**Addendum No. 1**

RE: Contract # C204684

**Haywood County (B-3186, B-5898)**

BRIDGES #155 AND 158 OVER RICHLAND CREEK ON US-23/74 AND  
BRIDGE #168 OVER US-19 AND US-23 ON US-23/74.

PROJECT REFERENCE NO. B-3186 / B-5898	SHEET NO. SIGN-41
SIGNING ENGINEER

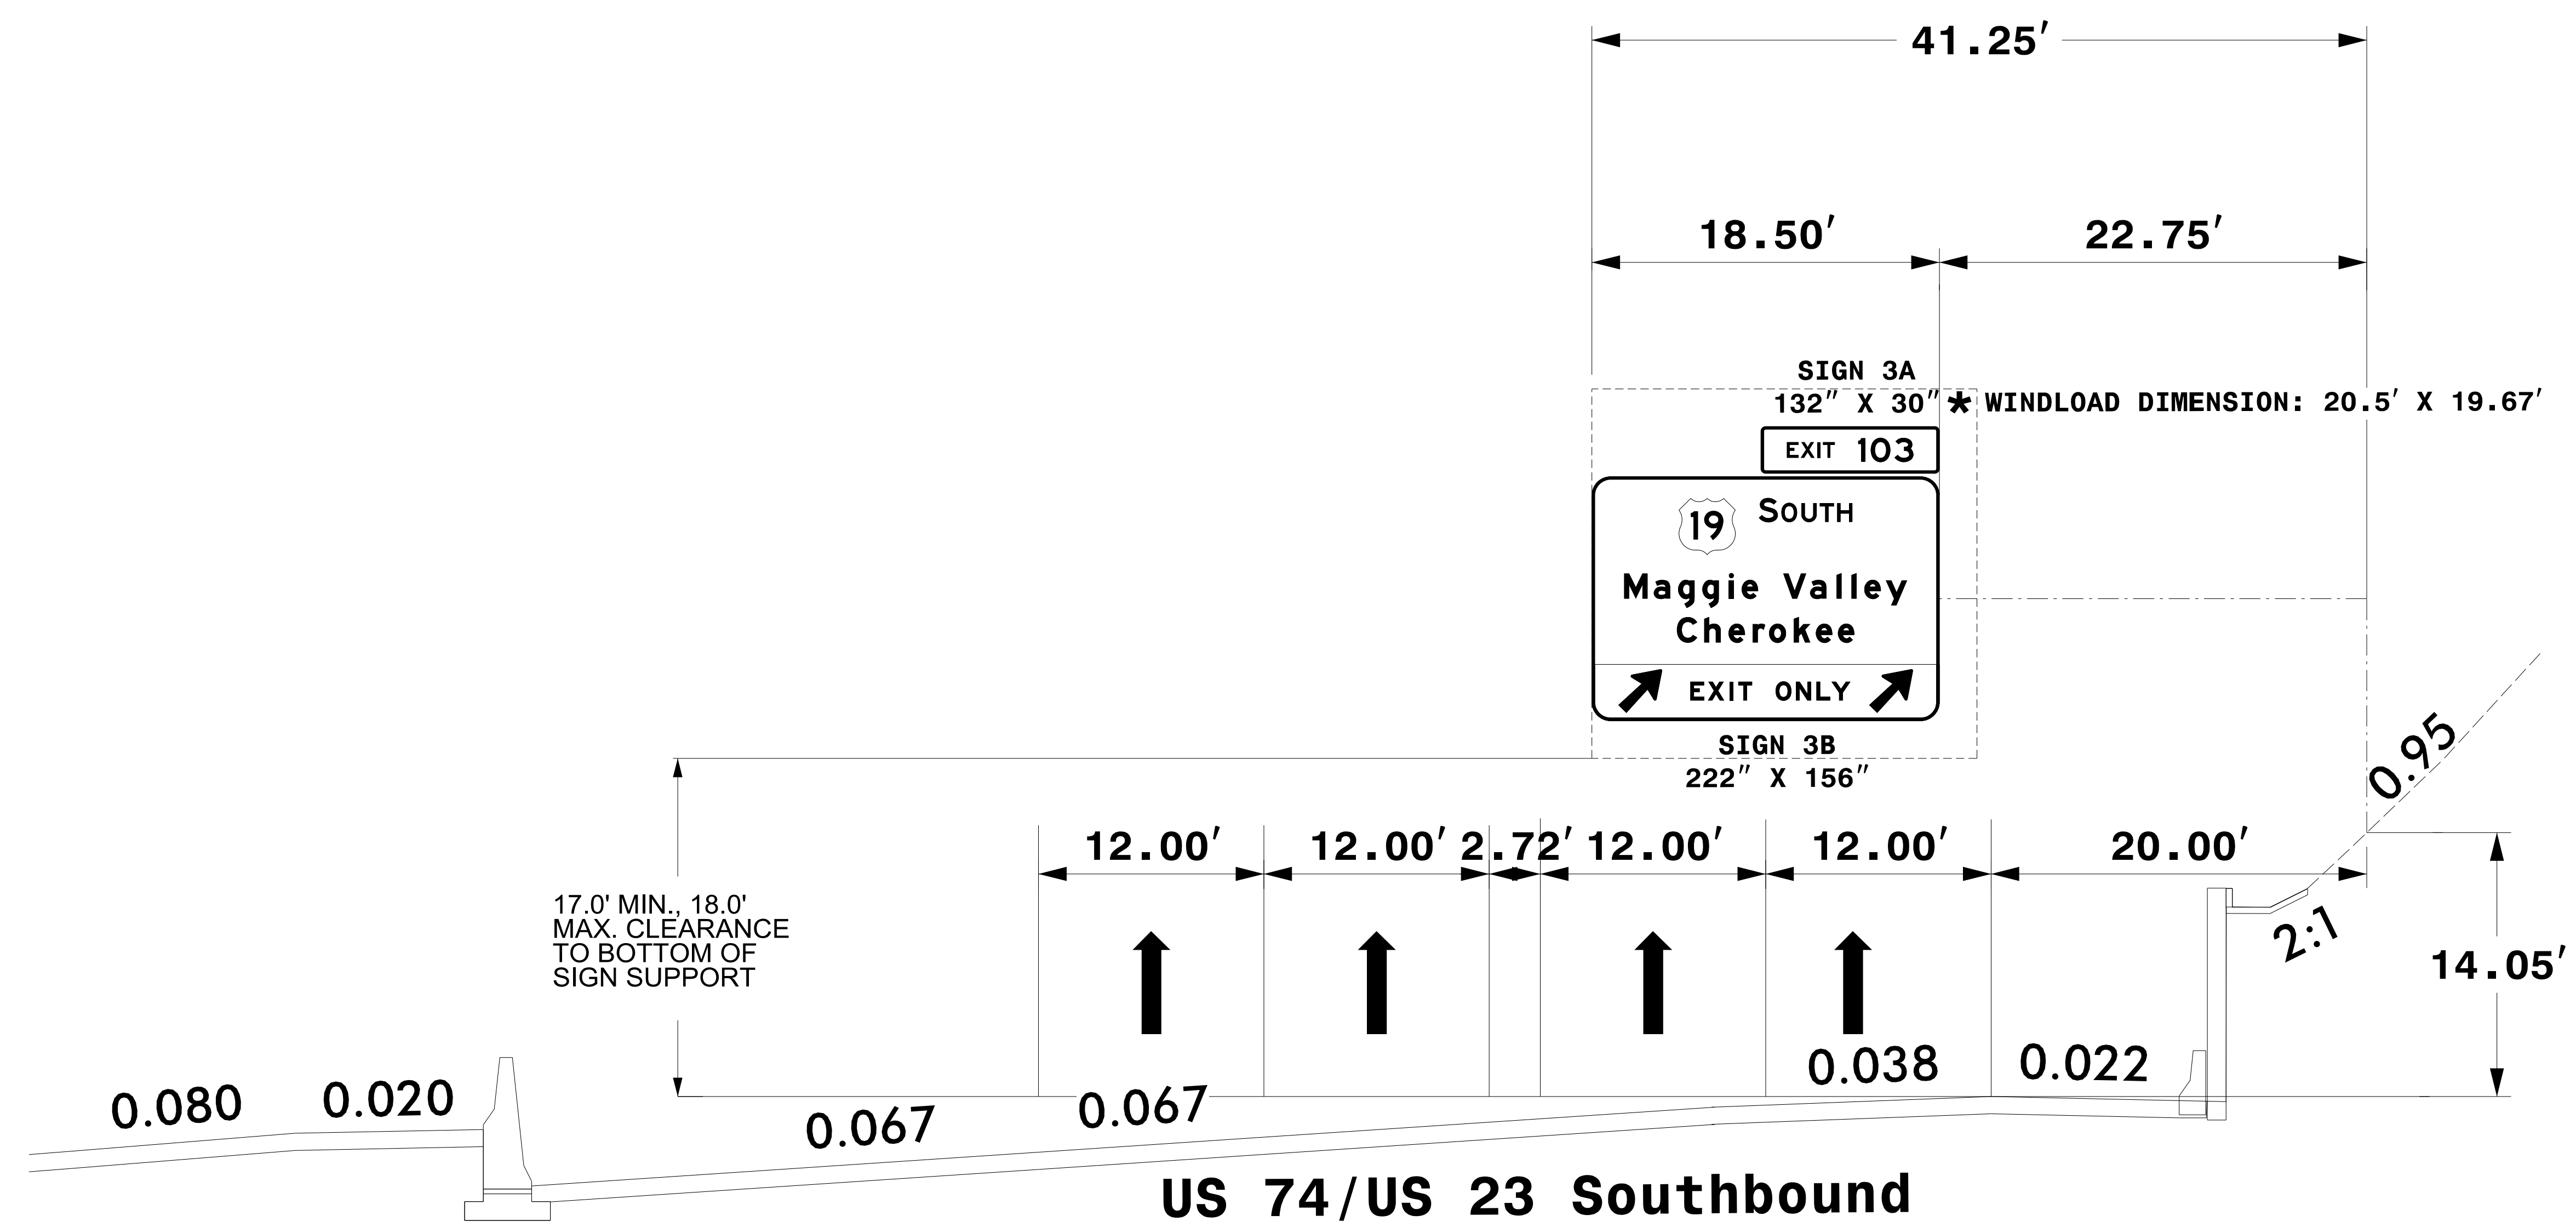
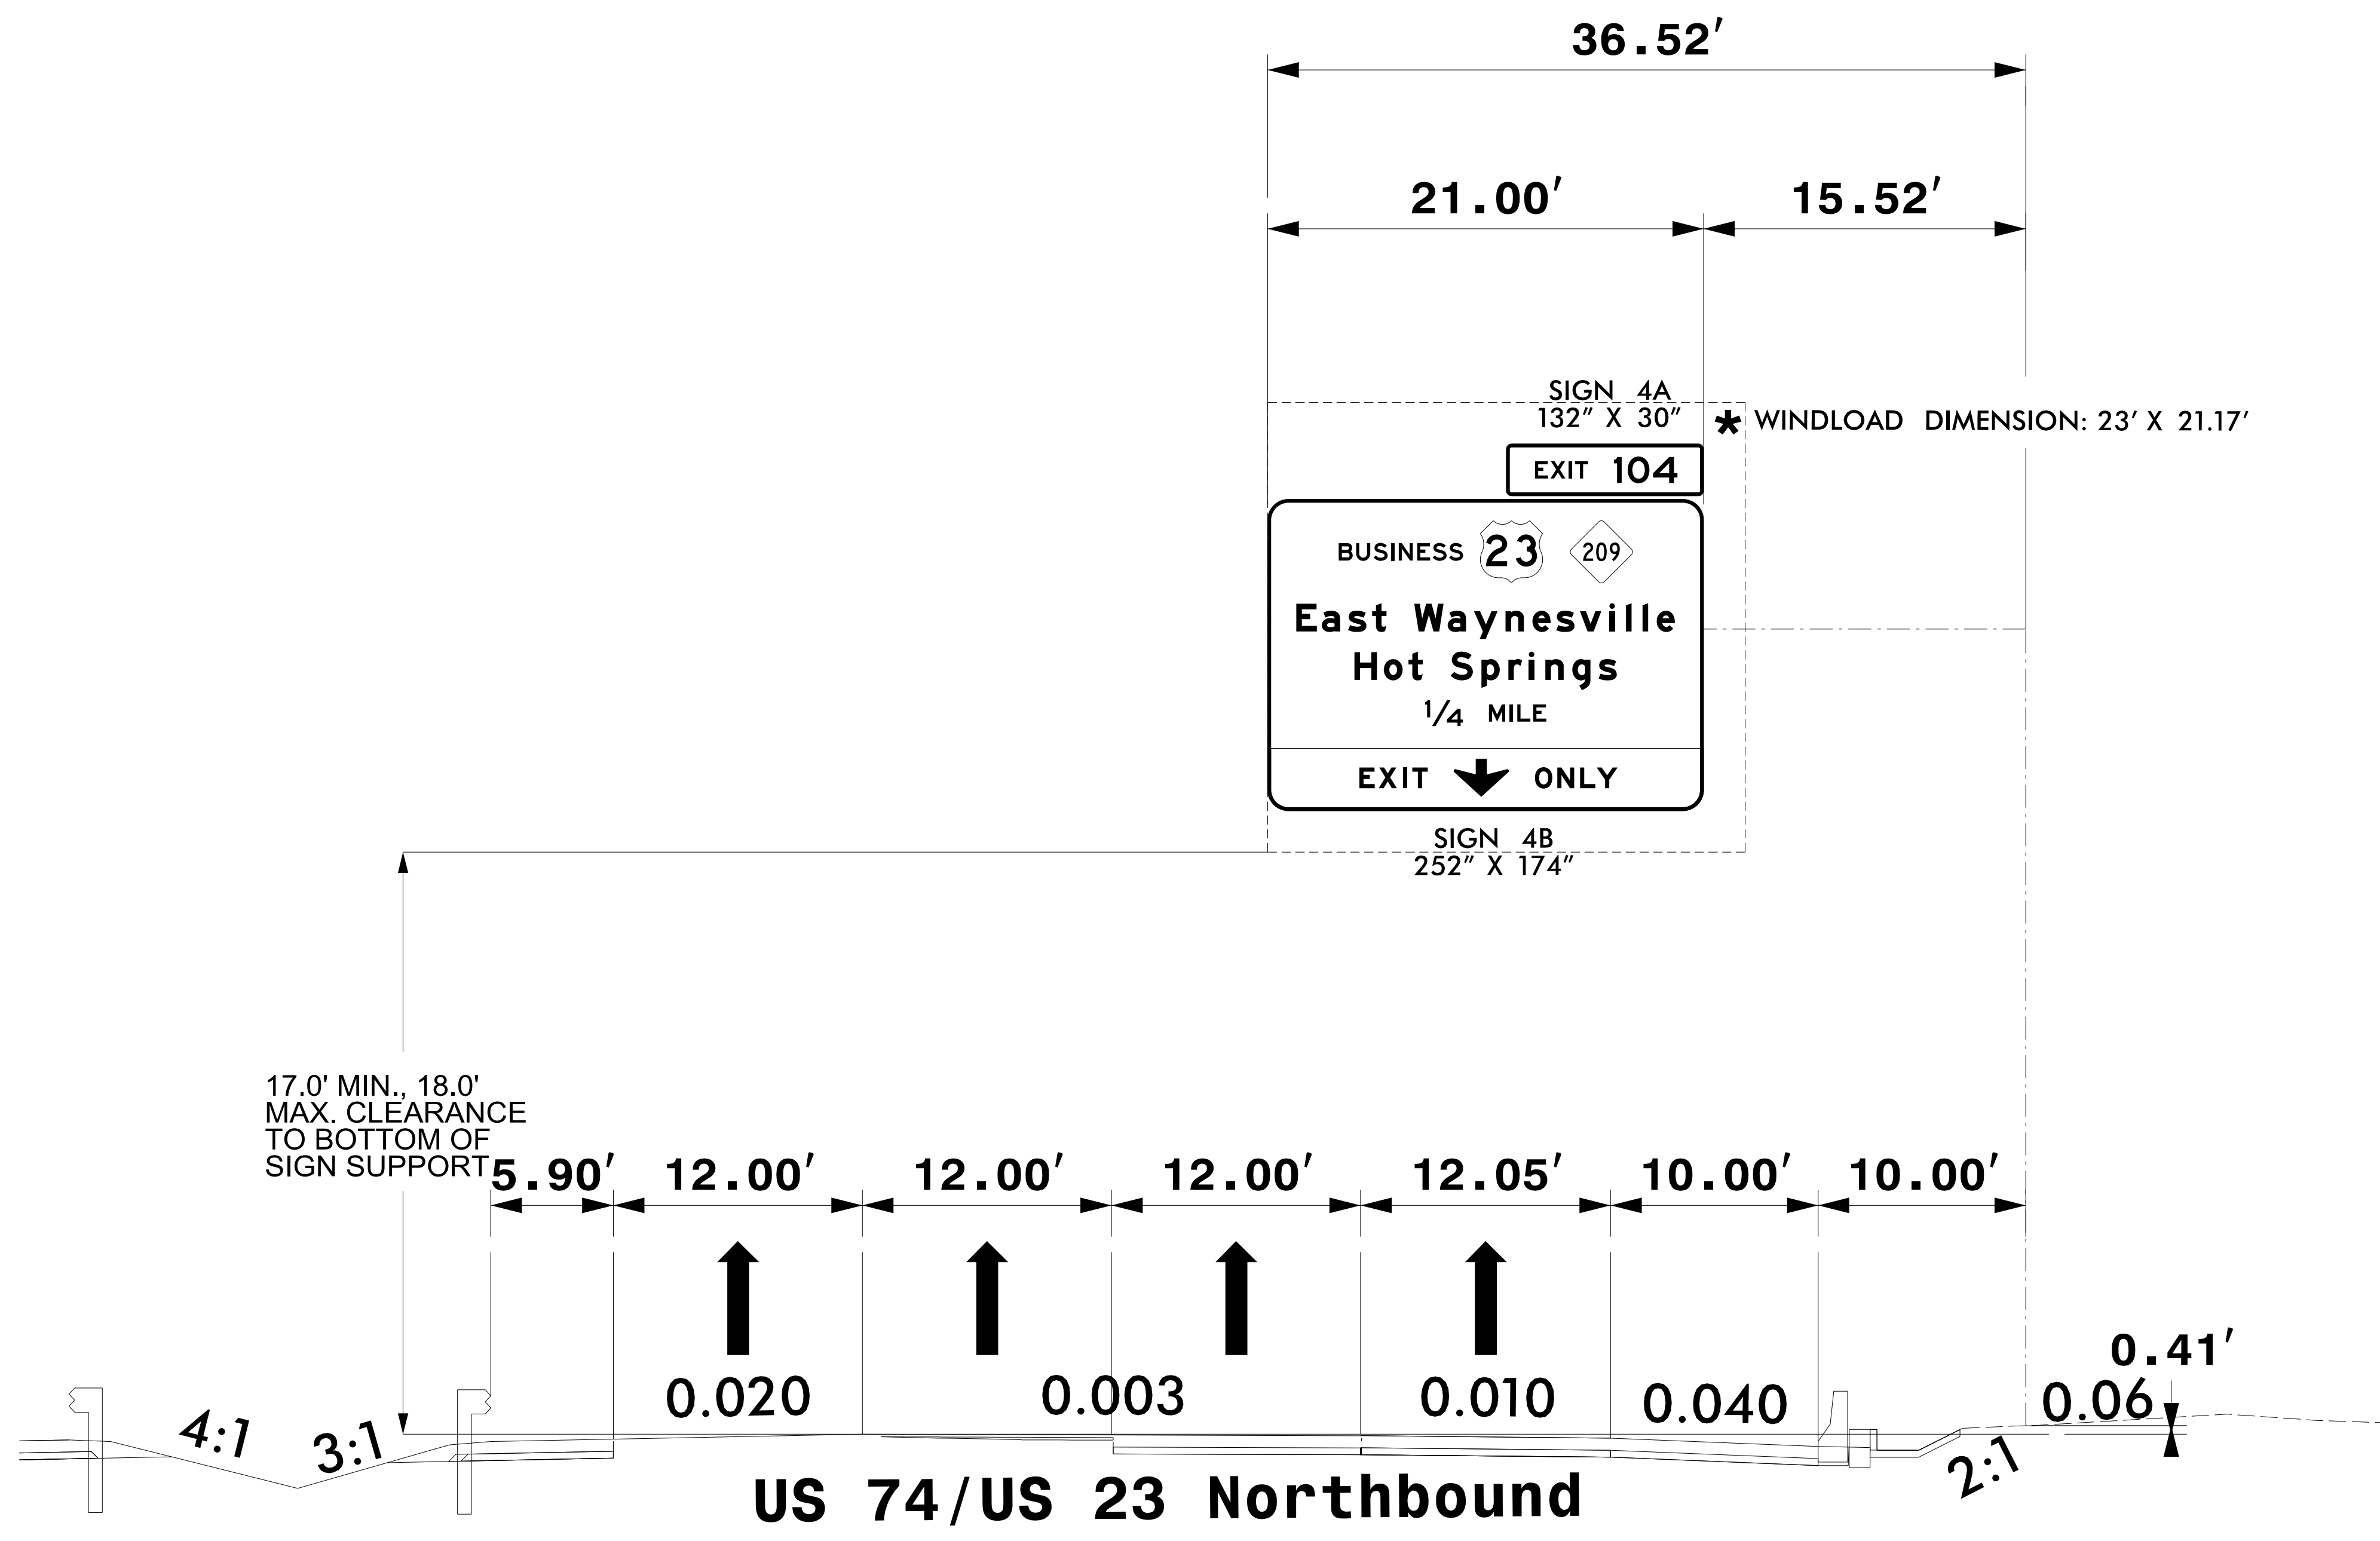
Sheet No.	Revision
SIGN-1	Quantities revised, removal of plan submittal block, and Roadway Standard Drawing list updated.
SIGN-2	Overhead Sign Assembly dimensions revised.
SIGN-2A	Existing Sign identifier numbers added, sizes revised.
SIGN-3 thru SIGN-5	Font, symbol, and panel sizes revised in sign designs. Milemarker signs clarified. Some signs modified to freeway sign size standards.
SIGN-6 thru SIGN-9	Added route labels and cardinal directions to roadways, revised project notes, and corrected sign number labels.
